TO: Dusty Pilkington, Community Development Services  
FROM: Kelly Bacon, Engineer Technician I *KB*  
DATE: April 9, 2018  
SUBJECT: Teanaway Ridge BL-17-00021

The Public Works Department has reviewed the Preliminary Survey for the Teanaway Ridge BL-17-00021 and find the following:

BOUNDARY LINE ADJUSTMENT

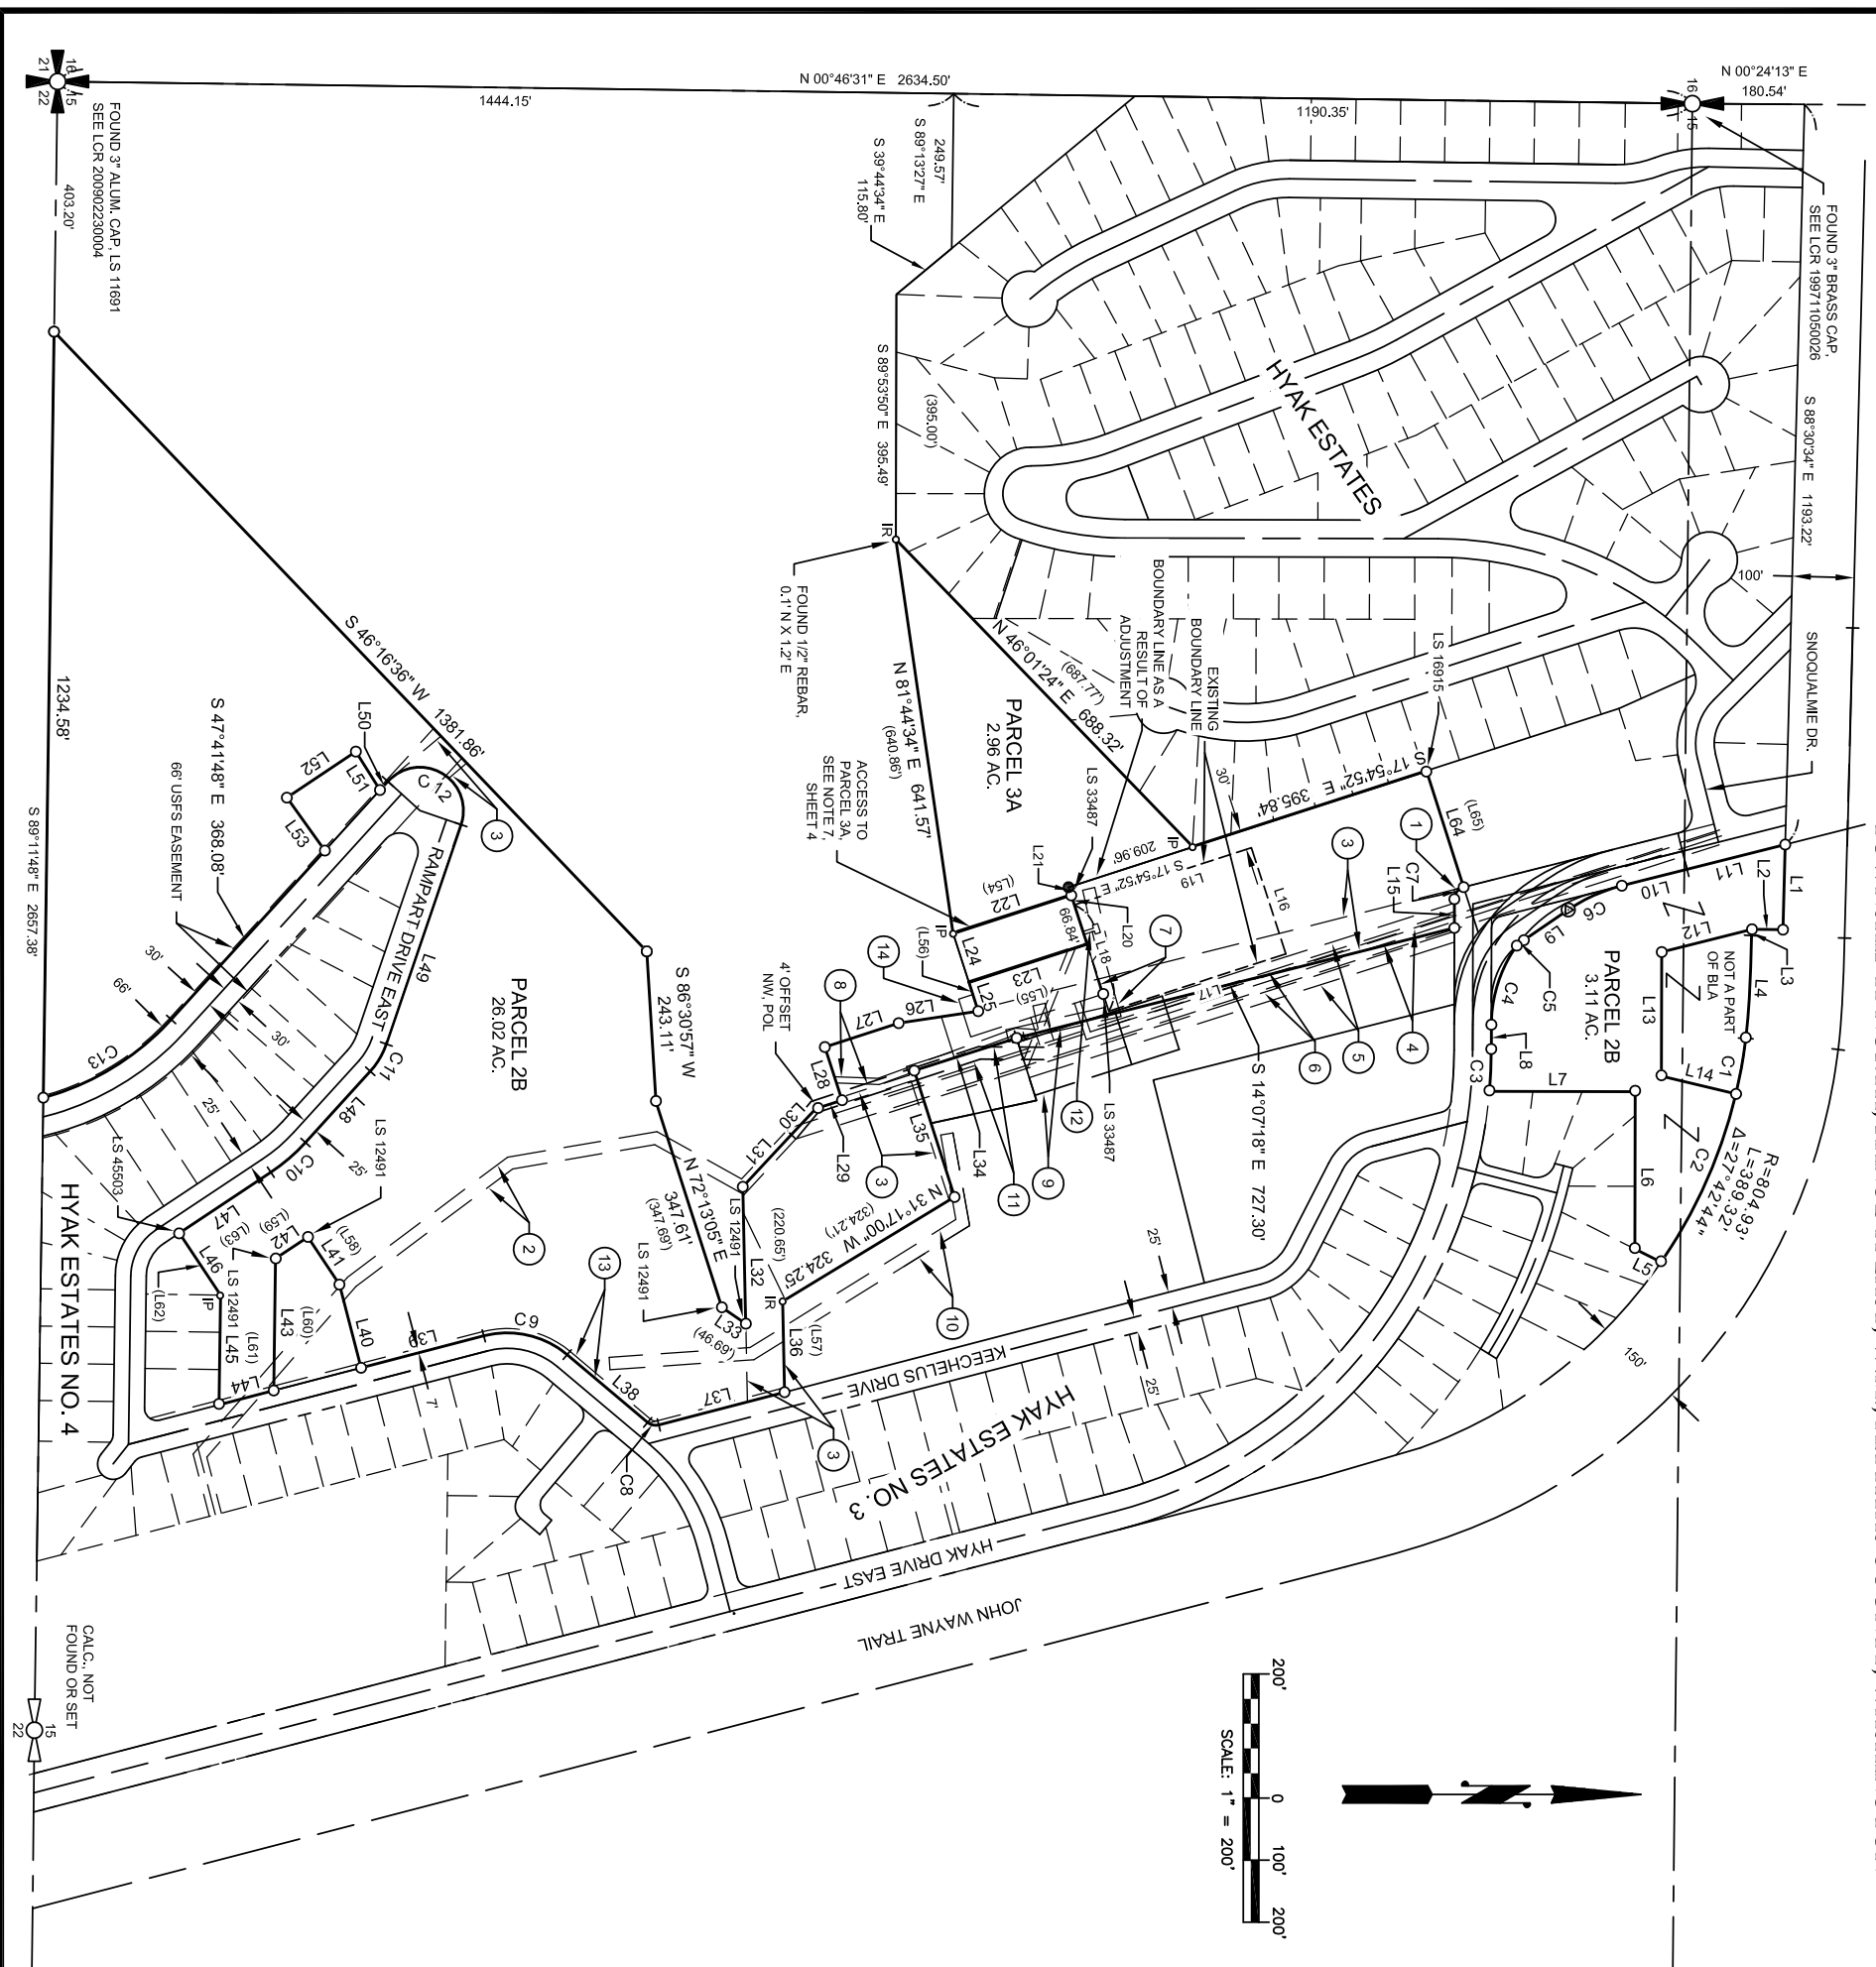
1. The existing 30' access and utility easement (recording number 551003) showing for access to Parcel 3A and also to tax parcel number 388735, currently runs through tax parcels 13261, 13260, 13259, and 13258. A majority of these lots have homes located on them and access through this existing easement would not be usable. Please provide an easement for access to these two lots.
